Department of Industry

OUT18/13129

Wellington North Solar Farm (SSD 8895) EIS Exhibition

## **APPENDIX B PROPOSAL PLANS**

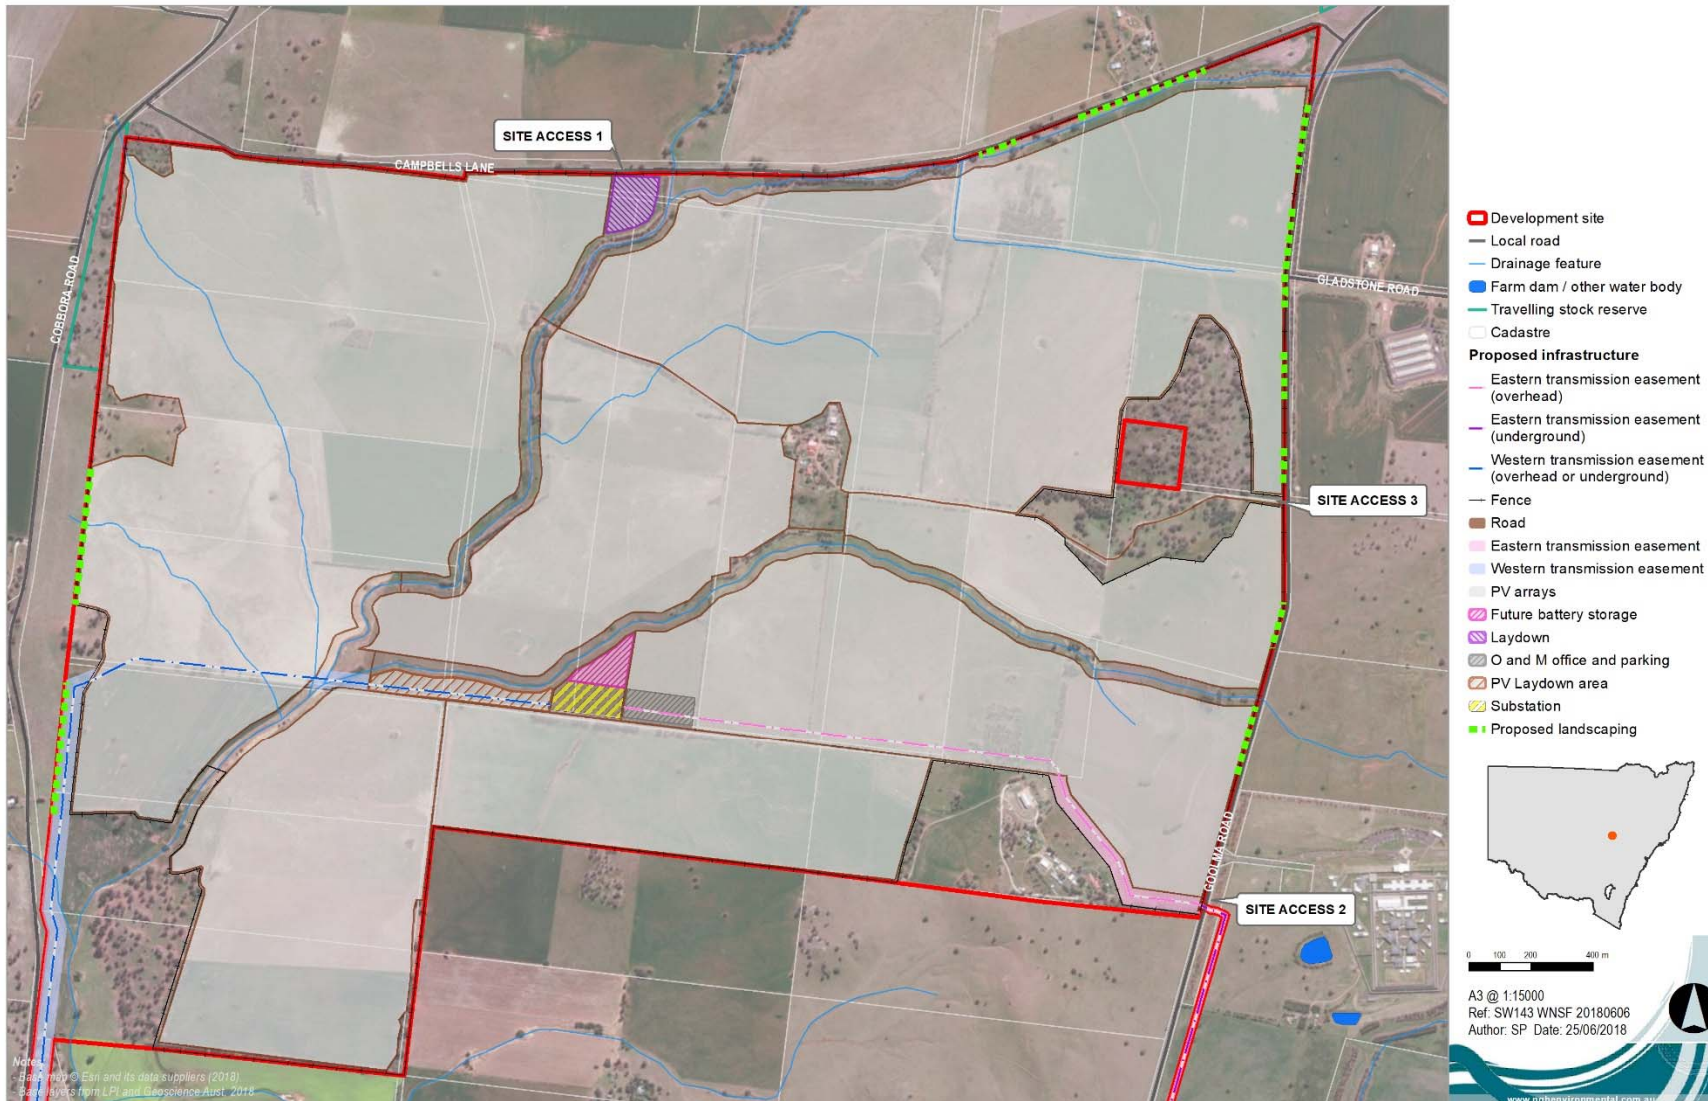
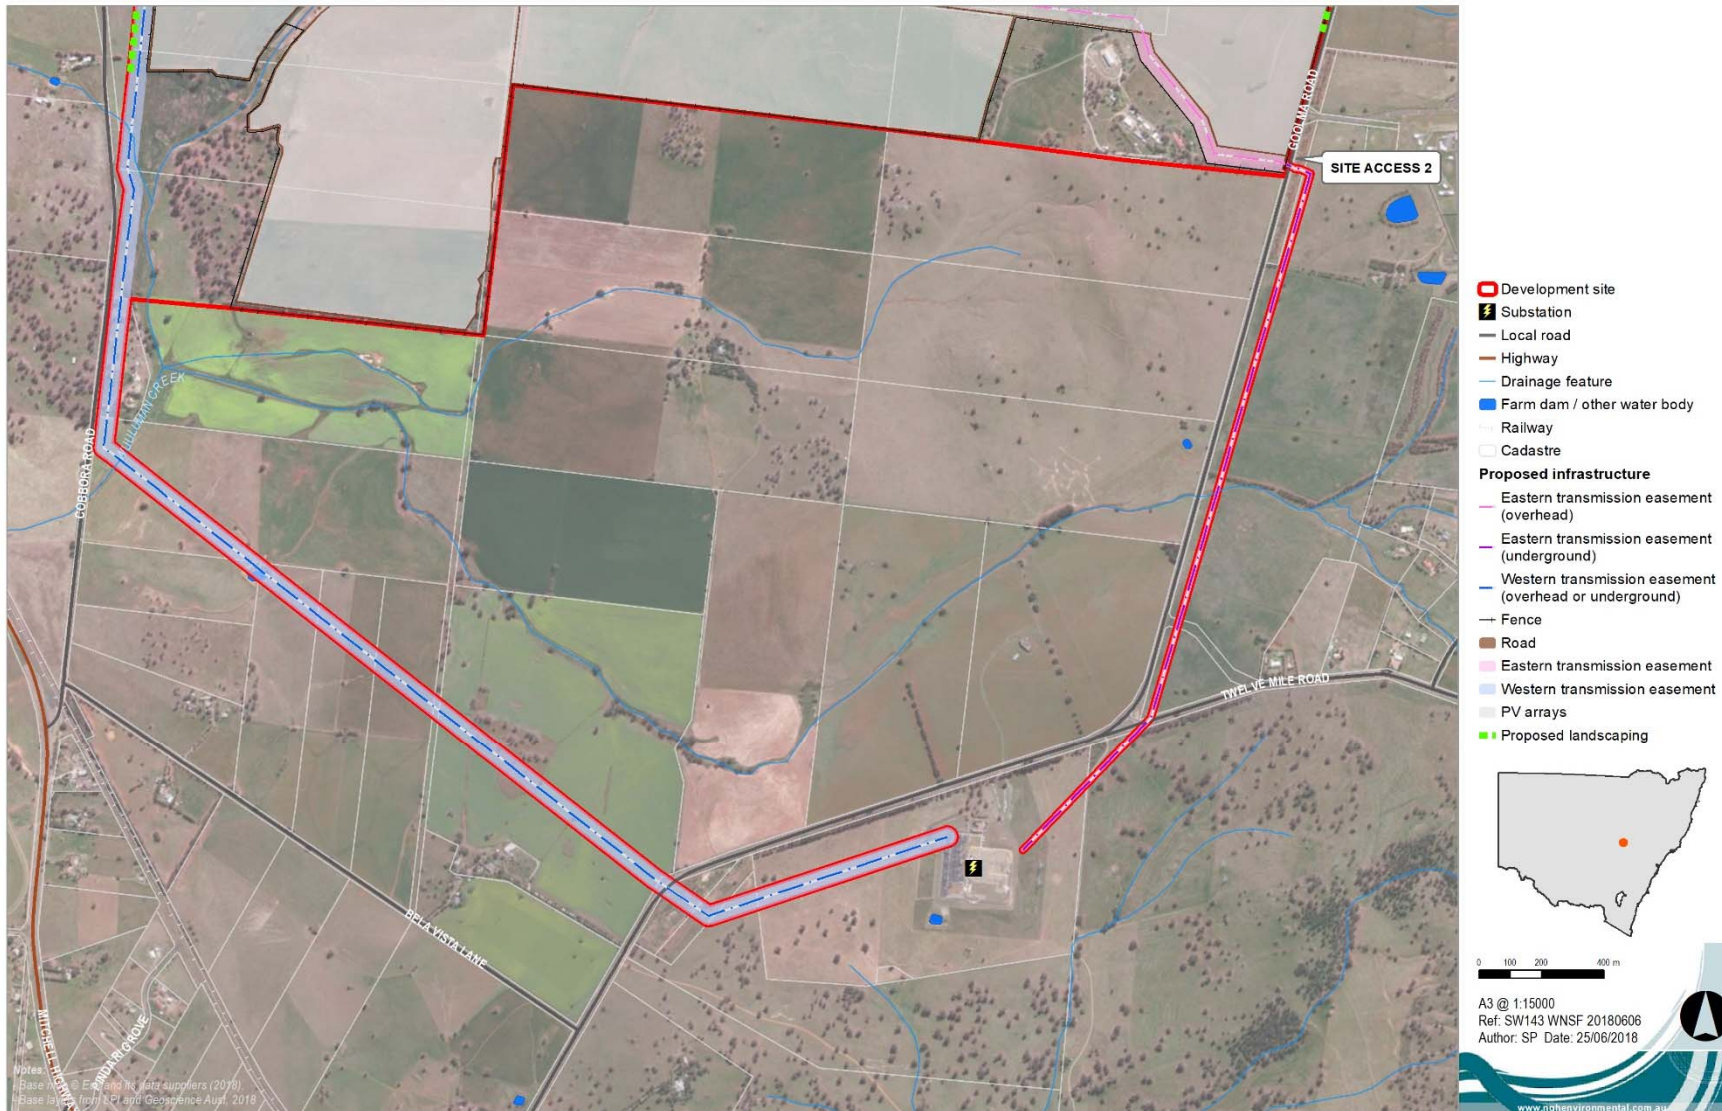
- A number of mapped watercourses exist on site, including a mapped 4th order watercourse that crosses from the north to the south western corner of the development. The proponent has identified this watercourse as a 3rd order stream and has stated that they will maintain a 30 m buffer. This is not consistent with the Guidelines for Controlled Activities on Waterfront Land (Natural Resources Access Regulator) for a 4th order watercourse.

- It is noted that the proponent proposes to construct internal access roads over identified 1st and 2nd order watercourses in accordance with the Guidelines for Watercourse Crossings in Waterfront Land (Department of Industry).

- The proponent should provide confirmation that a source of water has been secured for the construction and operation requirements of the proposed development.
- The proponent should maintain a 40 m buffer from the identified 4th order watercourse within the proposed development site per the 'Guidelines for Controlled Activities on Waterfront Land' (NRAR 2018).
- The proponent should construct proposed road crossings over 1st and 2nd order streams in accordance with the Guidelines for Watercourse Crossings in Waterfront Land (Department of Industry).
- If groundwater is confirmed as a source, it is recommended the proponent assess the impacts of extracting the required amount of water from the on-site bores.
